COMMUNITY DEVELOPMENT DEPARTMENT
501 Delta Avenue ♦ Marysville, WA 98270
(360) 363-8000

Re: Kendall Subaru – PA22-035 – Technical Review 2
16xxx Smokey Point Blvd – APN(s): 31052800300600 / 31052800300300 / 31052800301200

After review of the preliminary Site Plan Review, the Planning Division has the following comments:

FRONTAGE IMPROVEMENT PLAN **C5.0**

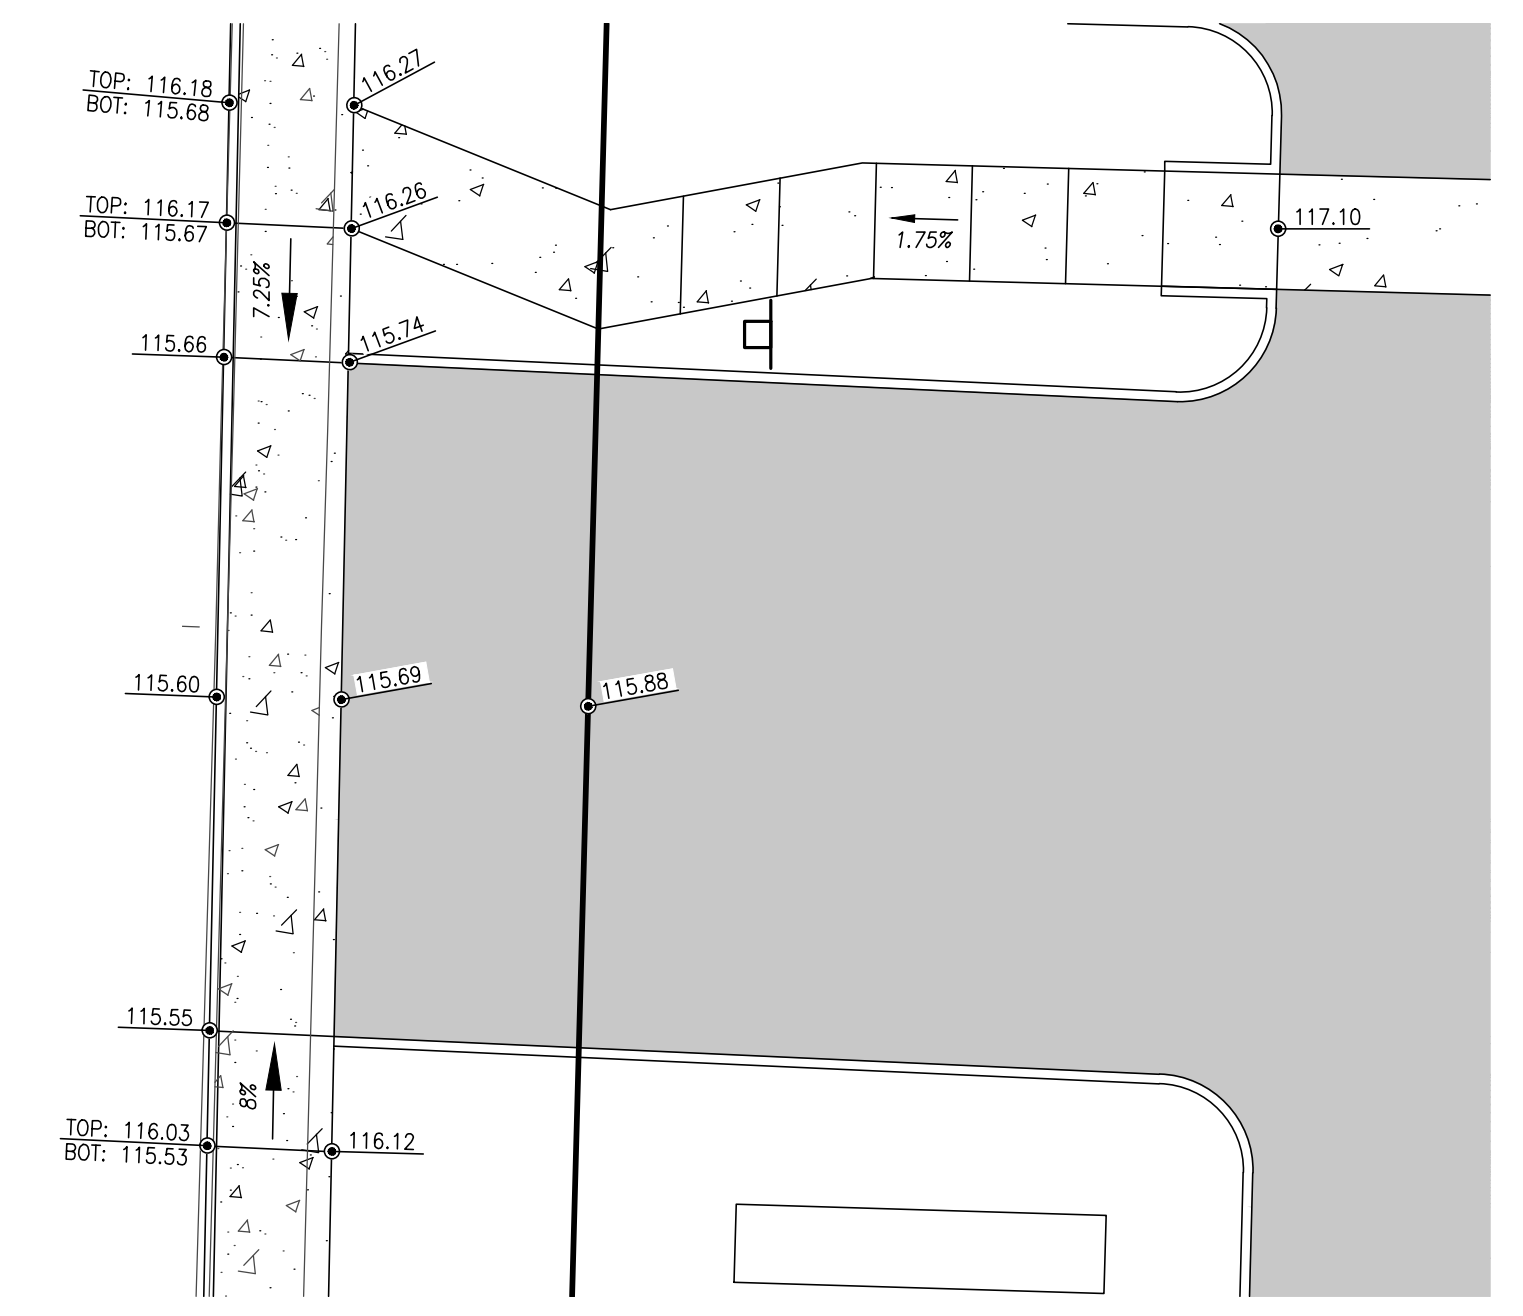
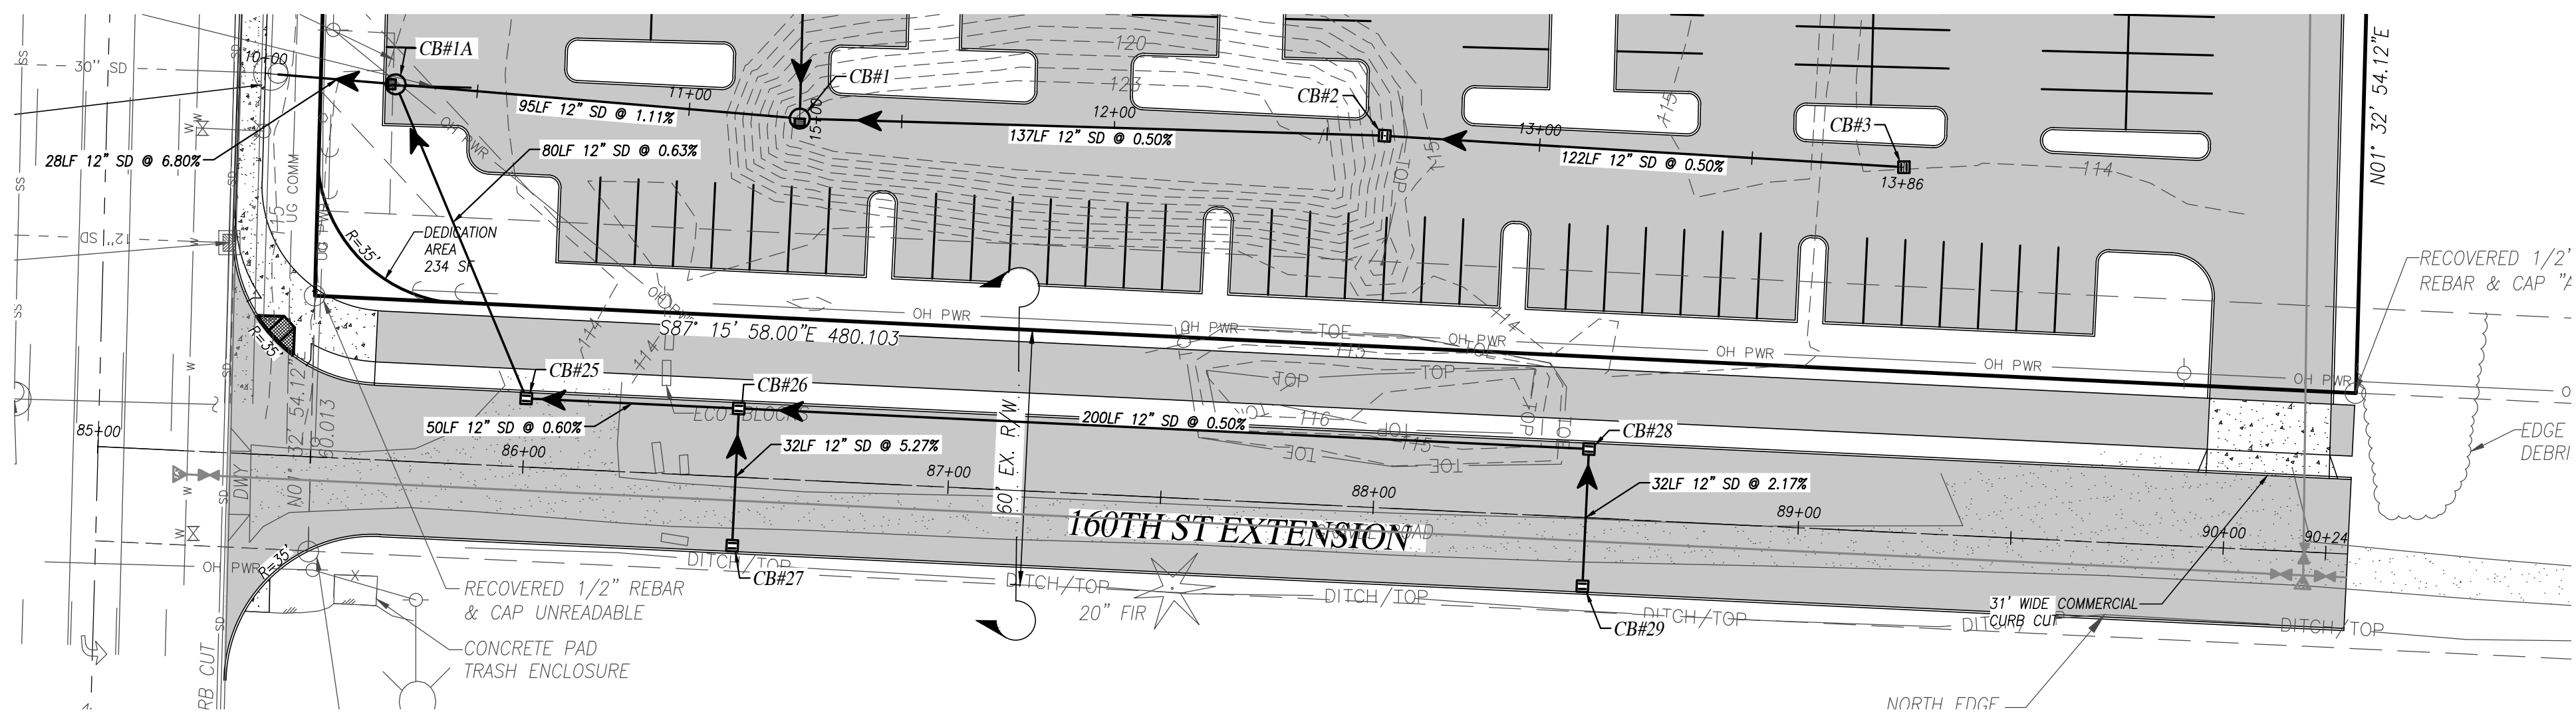
- 3) Frontage improvements shall be required upon Smokey Point Blvd.
 - a. Undergrounding of overhead utilities shall be required upon frontage.
- 4) ADA Curb Ramps:

- a. Per EDDS Standards, separation of ADA curb ramps is required at arterial intersections.
 - i. Separate curb ramps on Northeast corner of Smokey Point Blvd. & 160th ST NE intersection.

- i. Install ADA curb ramps on NW corner to cross unmarked crosswalk across north leg of Smokey Point Blvd. & 160th ST NE intersection.
 - c. Crosswalks shall not be marked at this time and will be marked in the future with signal construction.

SEWER AND WATER PLAN AND PROFILE C6.1

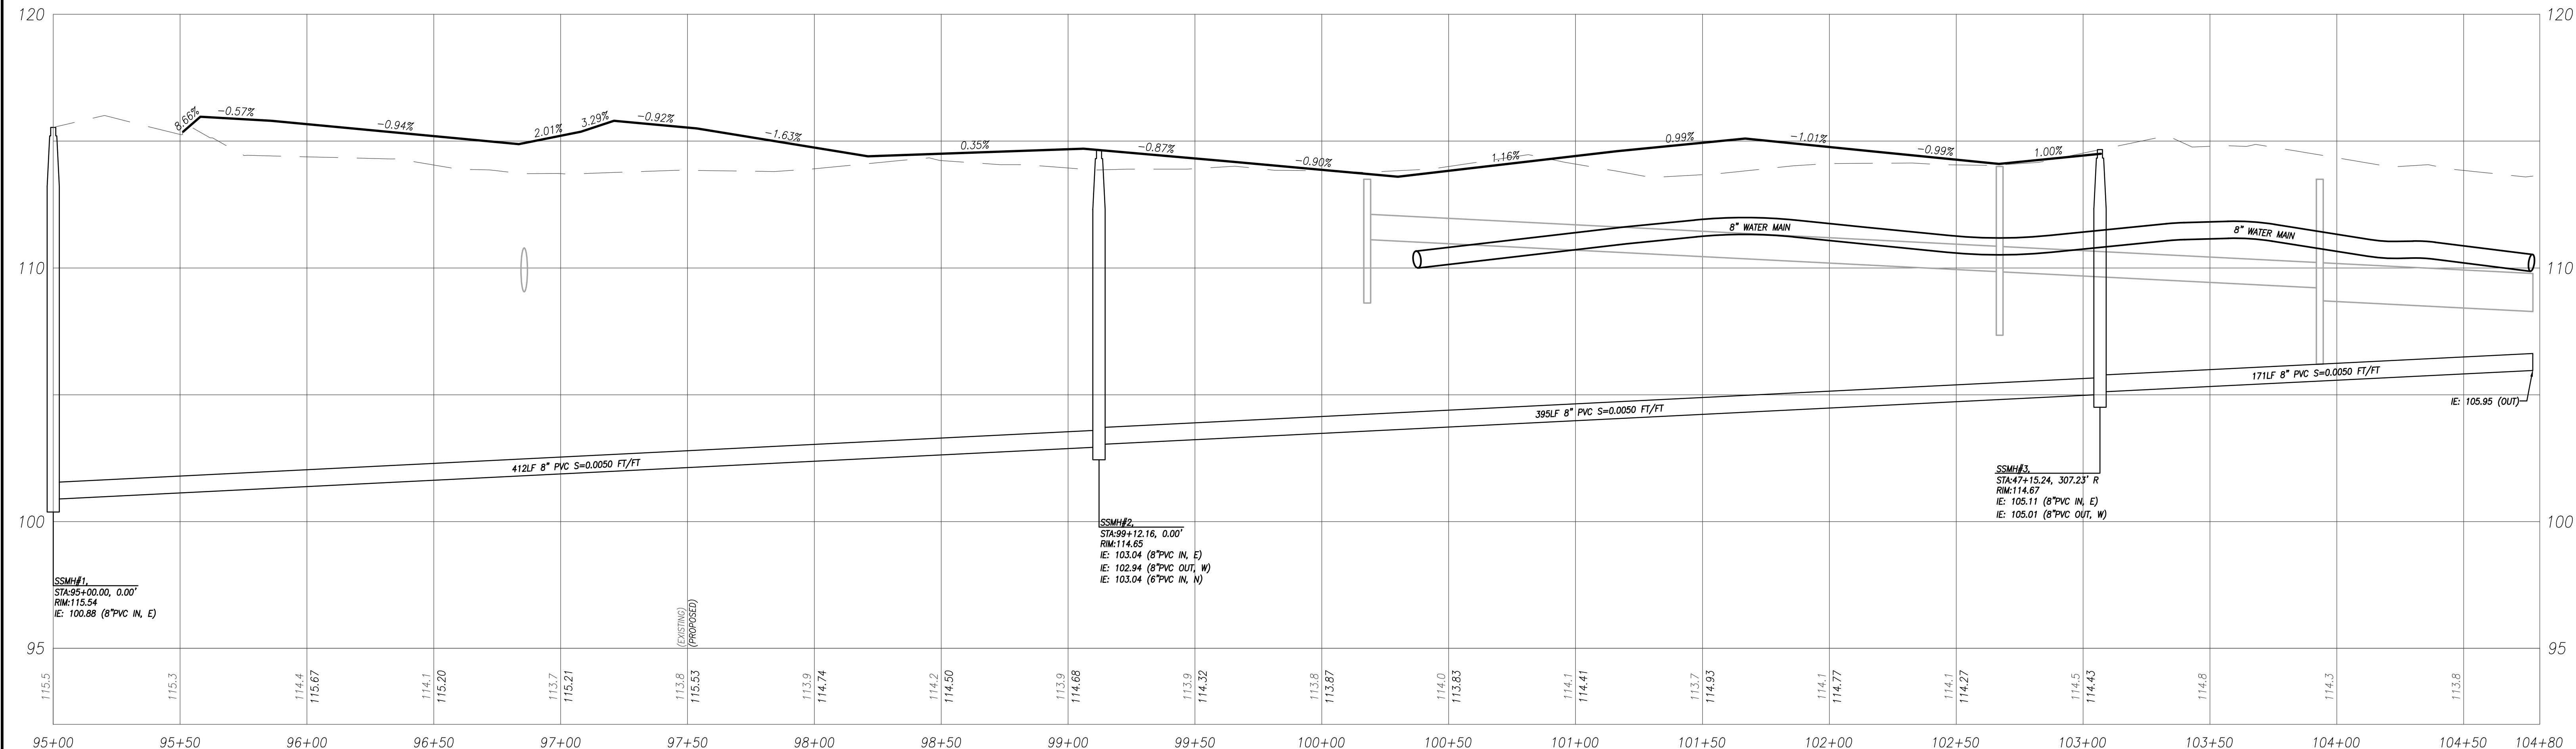
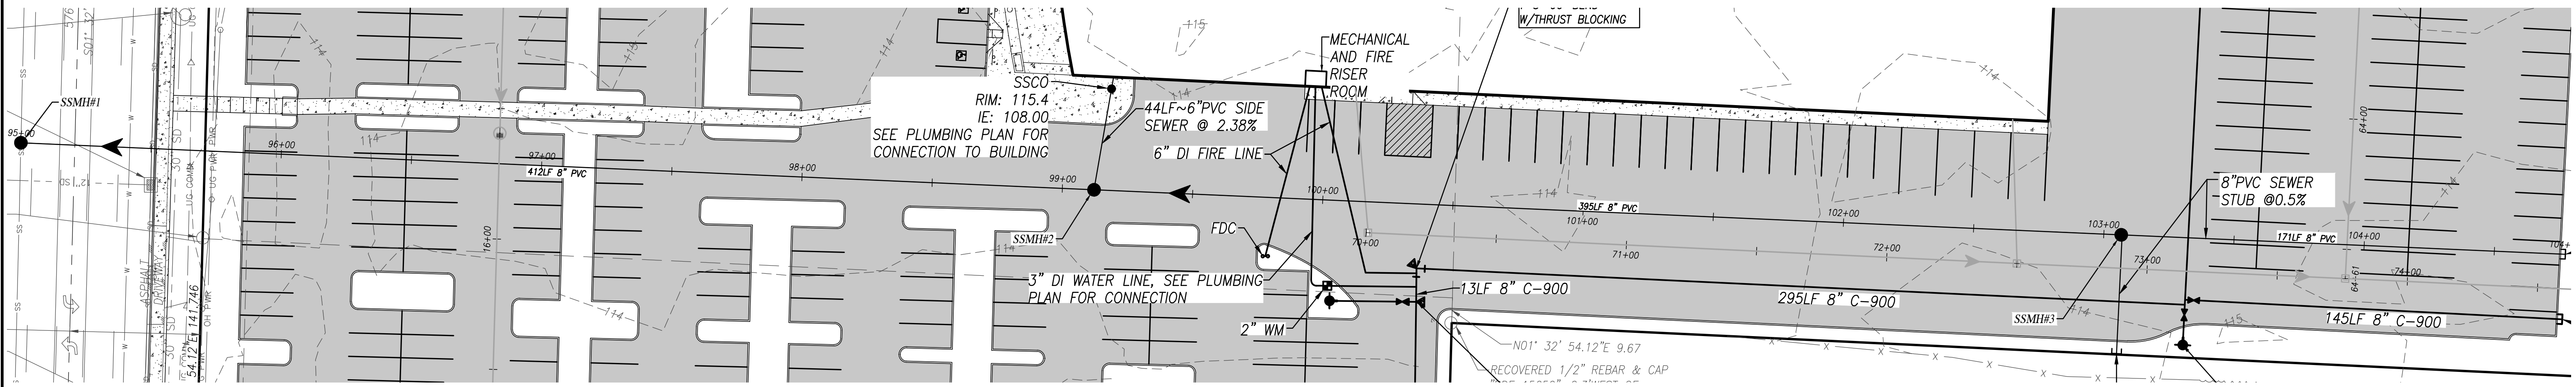
1. Water main on 160th St NE Extension will require a 2" blow off assembly at the end of the water main (STA 90+50.91);
2. 160th St Extension will require another hydrant assembly in accordance with Design and Construction standards 2-060 part D #3;
3. Water meter details not shown.
